Meeting note

Project name	Net Zero Teesside Project
File reference	EN010103
Status	Final
Author	The Planning Inspectorate
Date	15 September 2021
Meeting with	Net Zero Teesside Power Limited and Net Zero North Sea Storage Limited
Venue	Telecon
Meeting objectives	Project Update Meeting
Circulation	All attendees

THE NET ZERO TEESSIDE PROJECT

ADVICE FOLLOWING ISSUE OF DECISION TO ACCEPT THE APPLICATION FOR EXAMINATION

TITLE  
ACCESS AND RIGHTS OF WAY PLANS  
DOCUMENT REF. 4.5

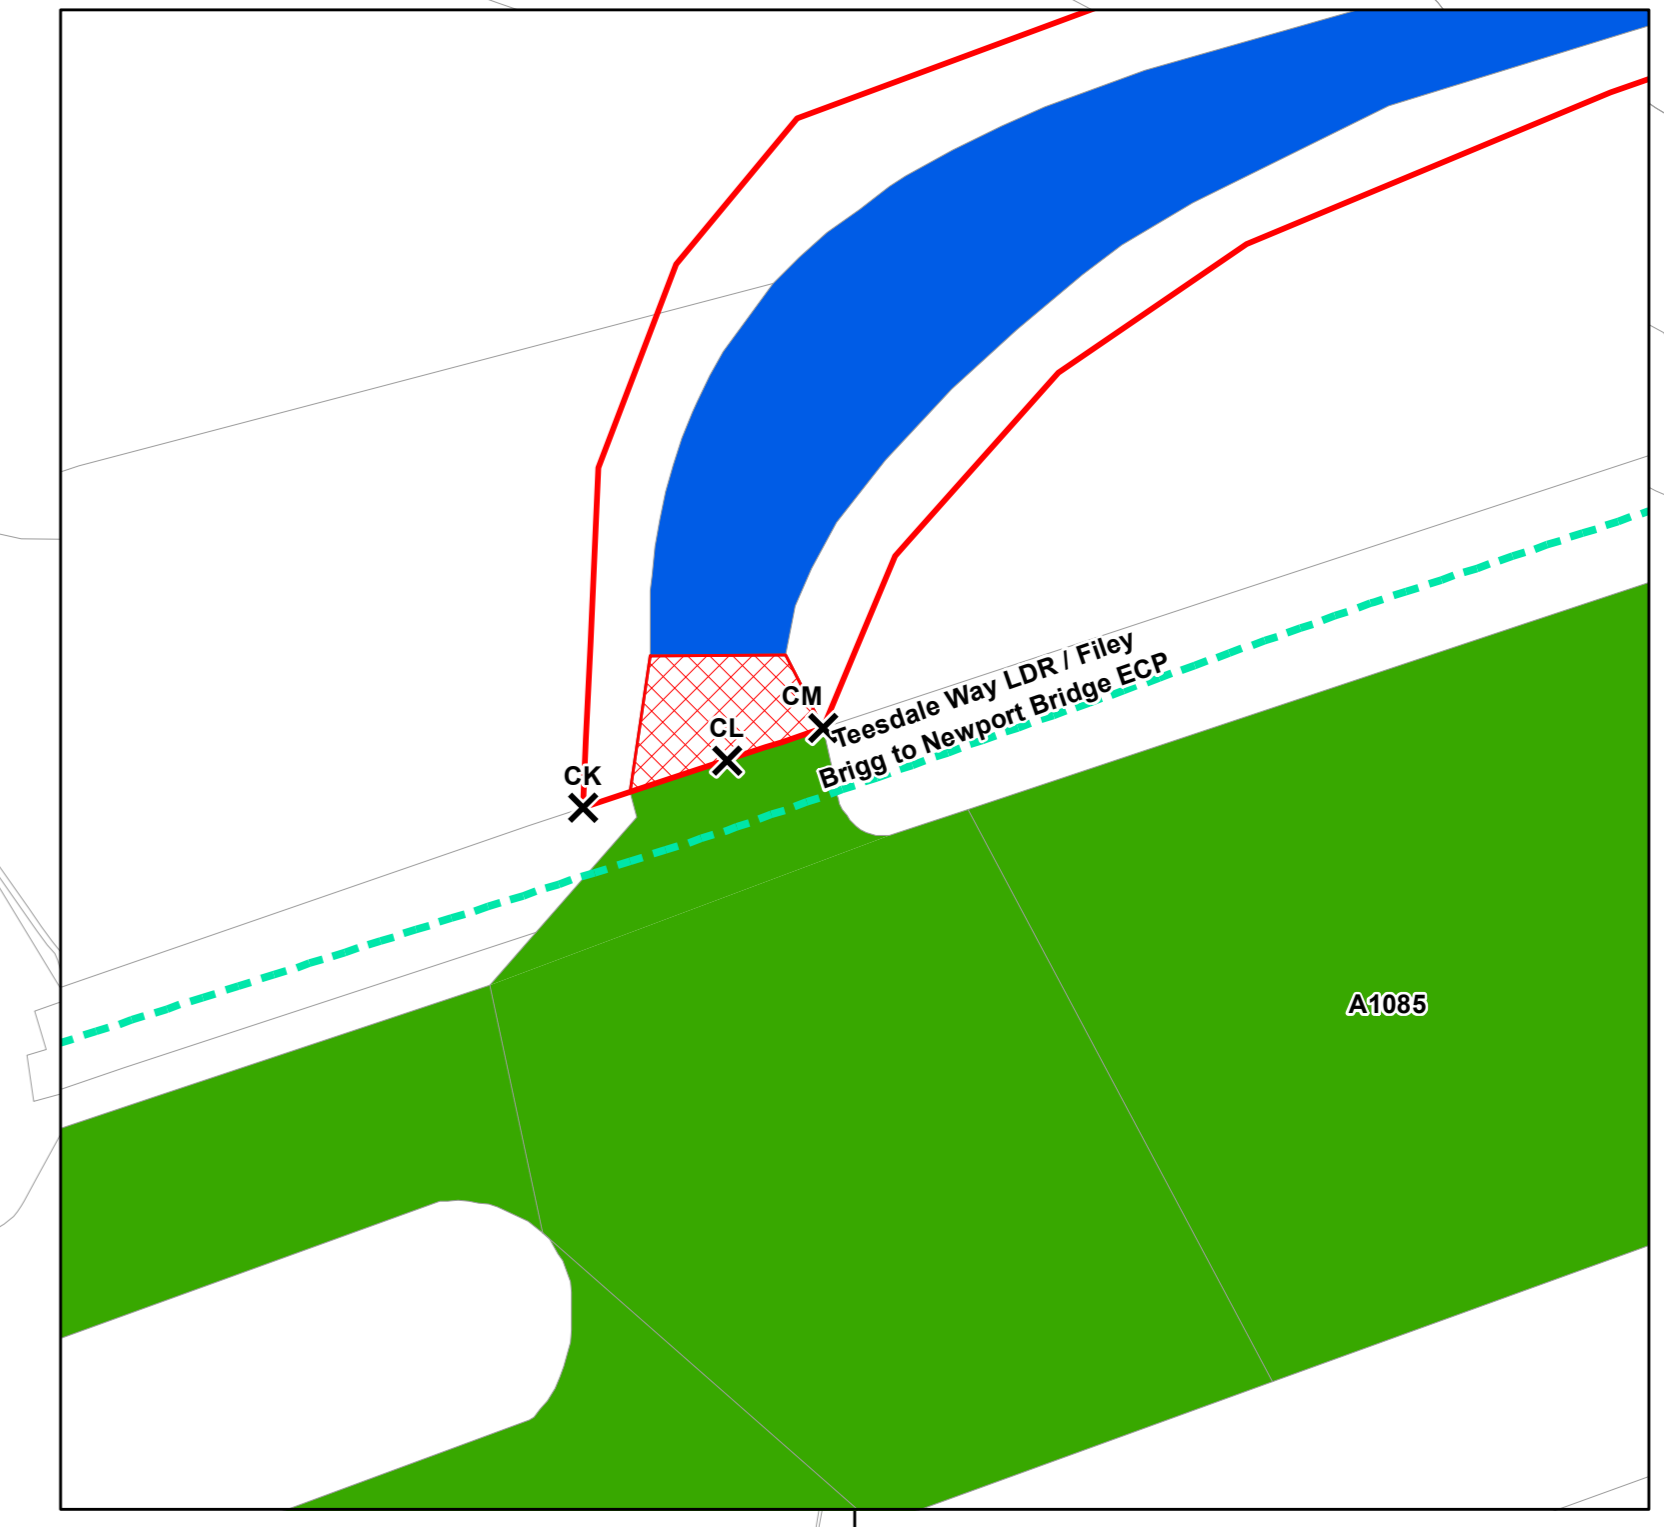
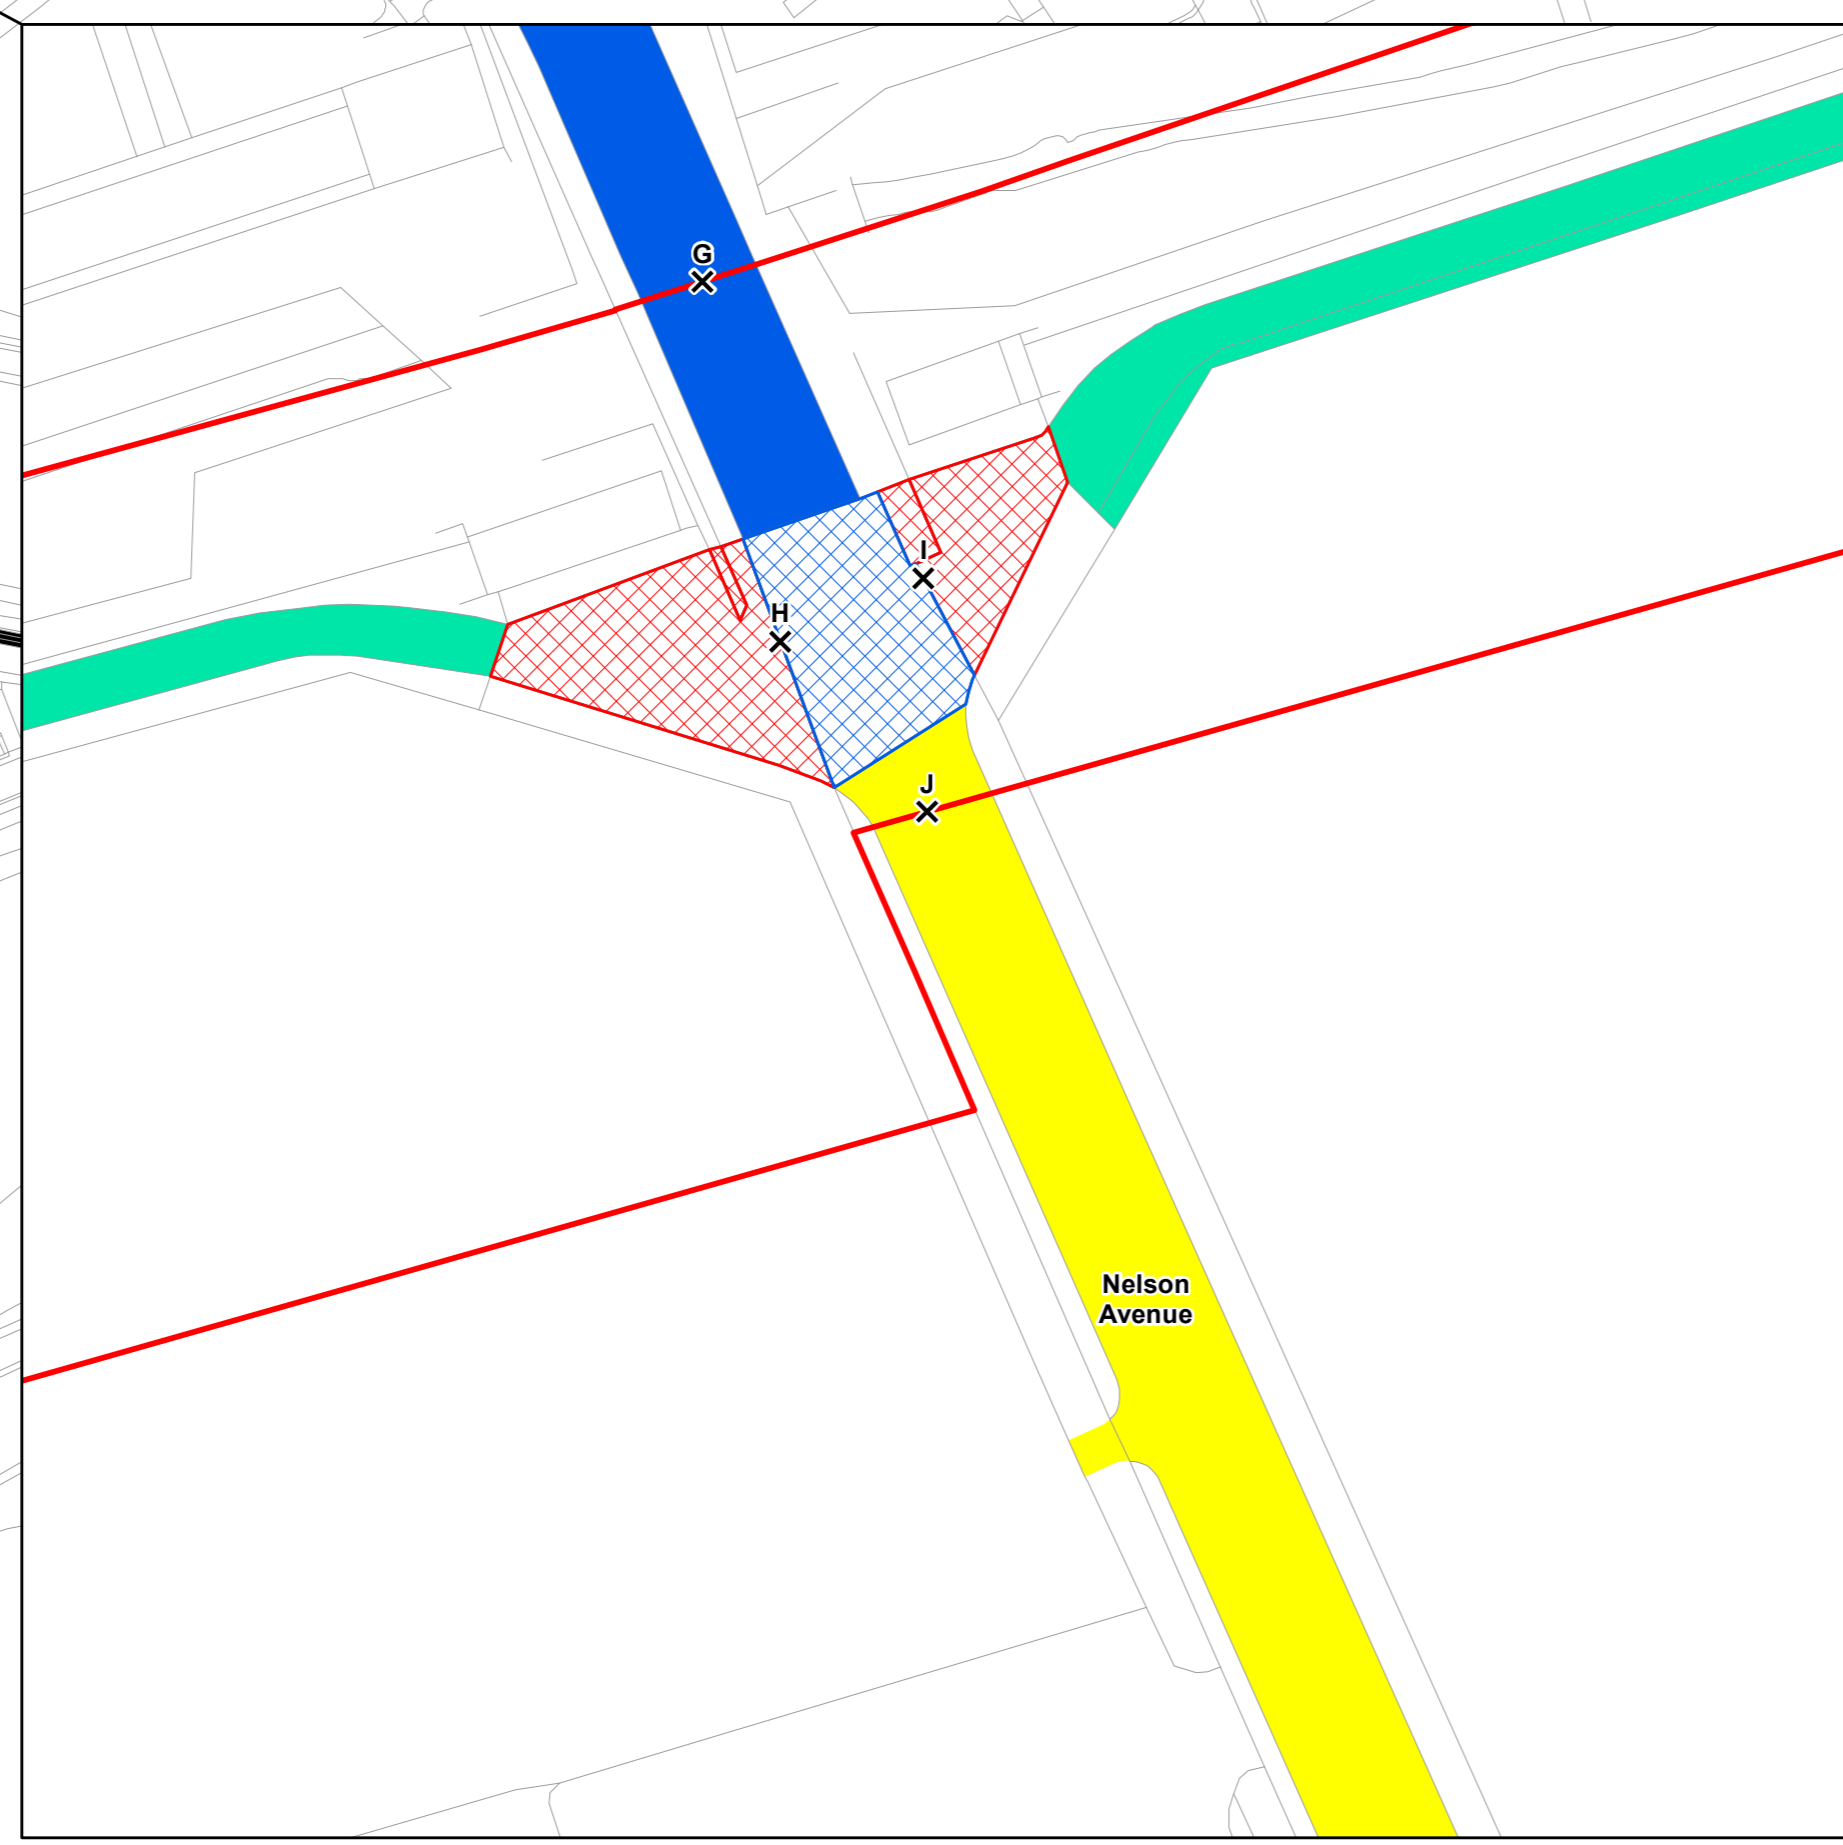
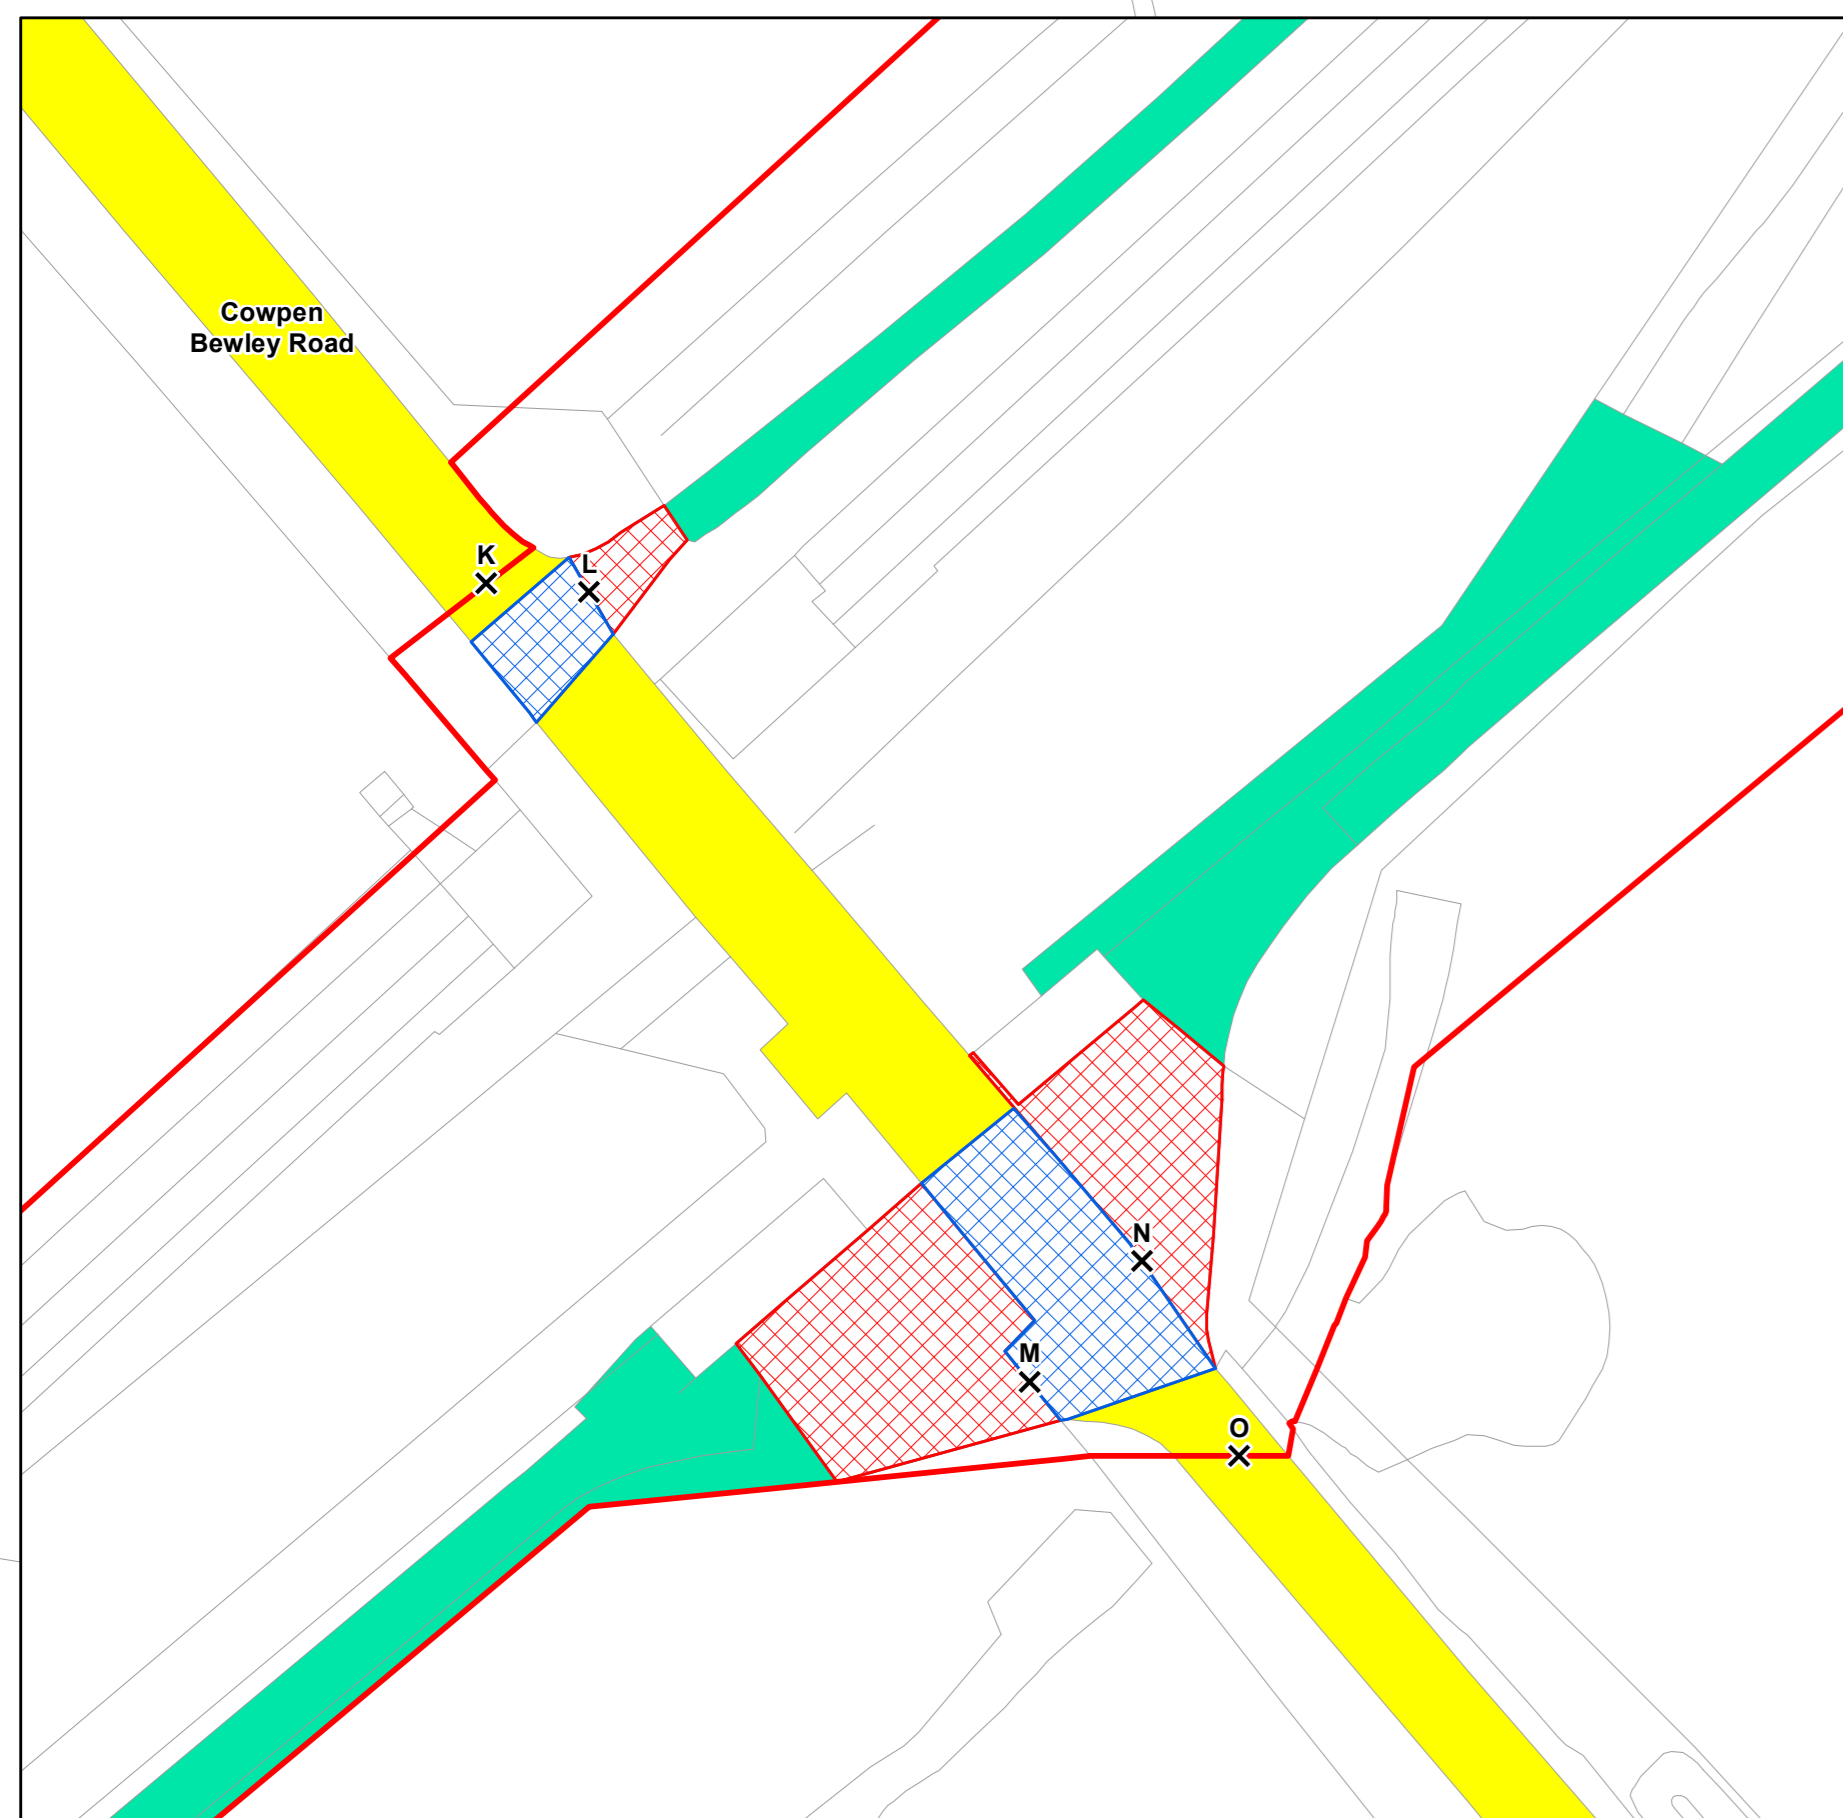
Access and Rights of way plans

The Inspectorate asked the Applicant to give a definition of what 'access land' meant on the Access and Rights of way Plans.

The Applicant explained that; access land is land over which the public has right to roam (Countryside and Rights of Way Act 2000); this was defined in Article 2 of DCO. The power to temporarily stop access to this land is in the DCO. The Applicant will provide an additional sheet to the Access and Rights of way Plans to better show the access land on the beach and dunes to North East.

The Applicant shall review the Explanatory Memorandum on this matter to ensure clarity.
